Anita Gardner
Principal Planning Officer,
Directorate of Place

Almost all of my points have been covered off on this one. Unfortunately there are still issues regarding the soakaway and pipe work under the parking area. The drawing states that soakaways have a cover depth of 600mm,

Drawing:
Surface water drainage

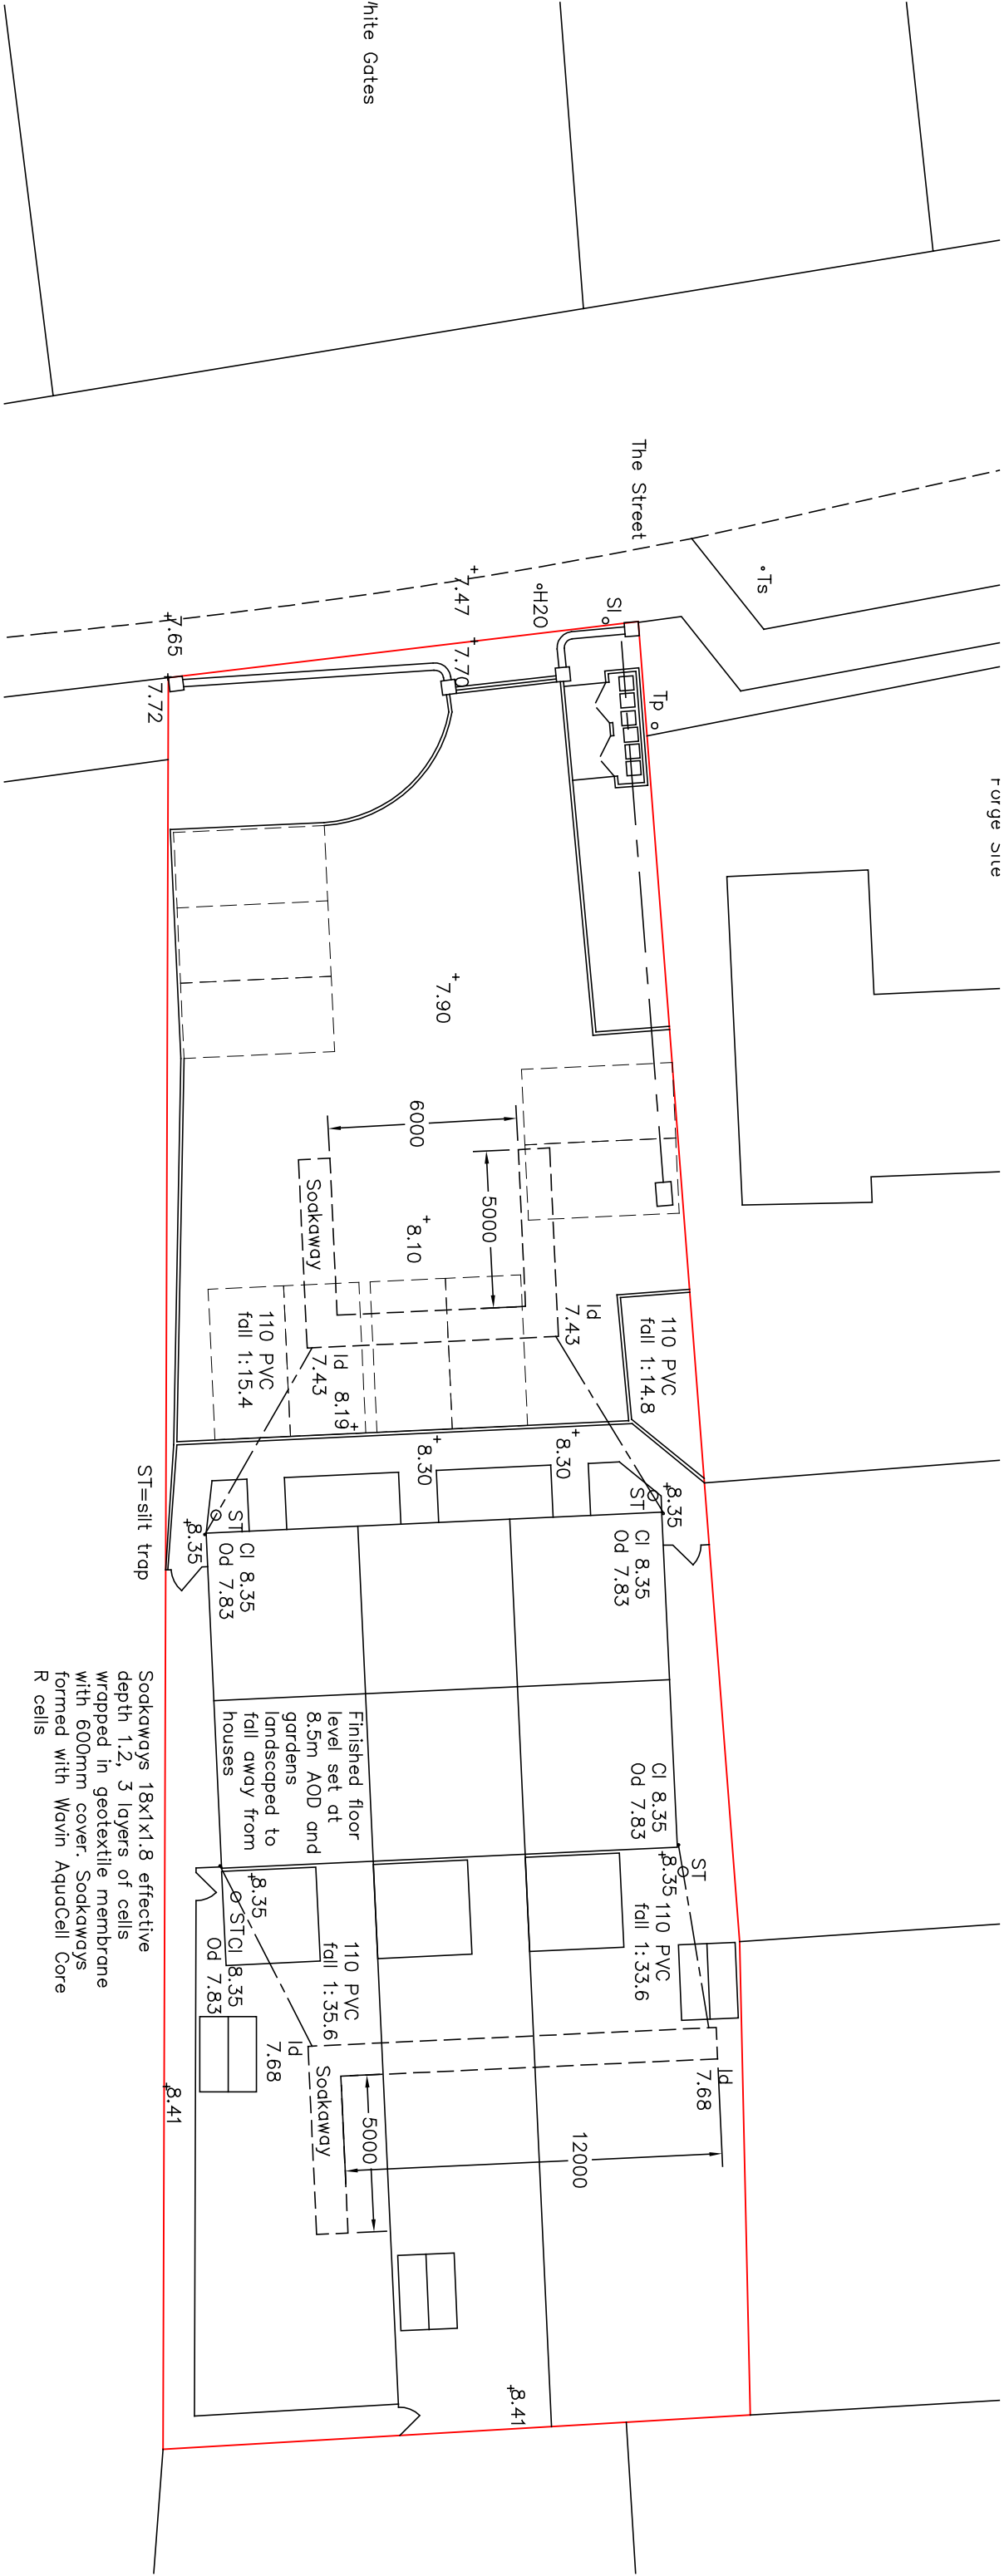
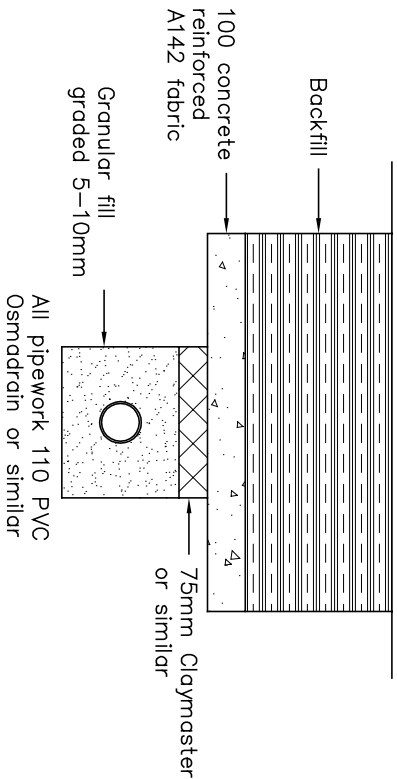
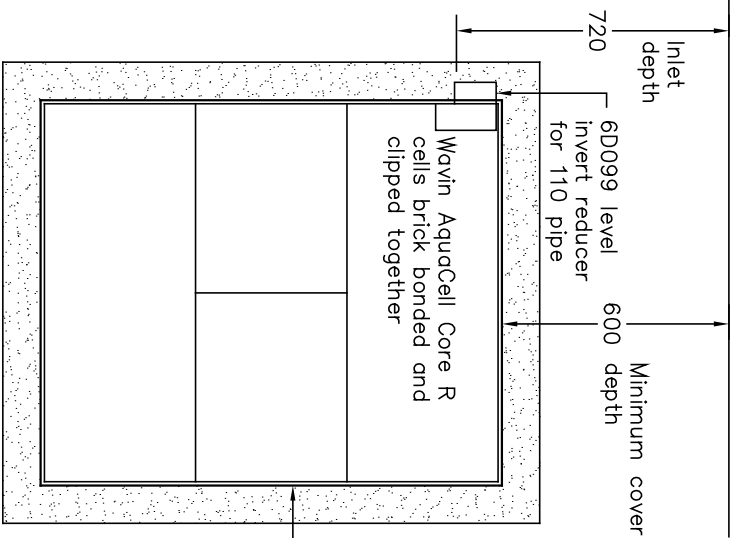
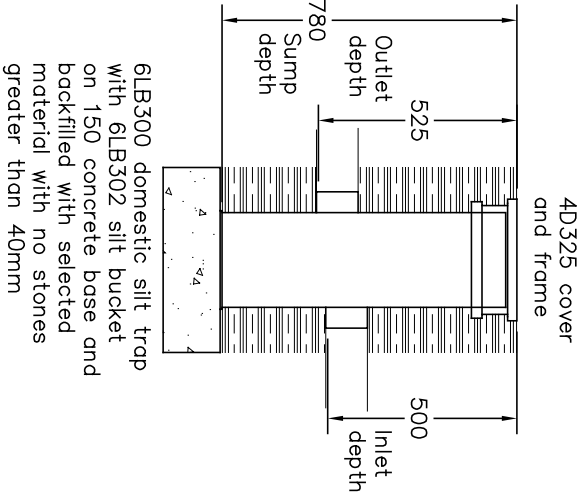
yet the west soakaway is laid under the car park. According to the BBA Certificate for the product (Table 9 page 8), the minimum cover depth under vehicular areas should be 700mm. We would also need to see a concrete bed and surround for the pipes under the parking area (Class Z). Once these issues have been rectified on the drawings I shall be happy to recommend discharge of conditions.
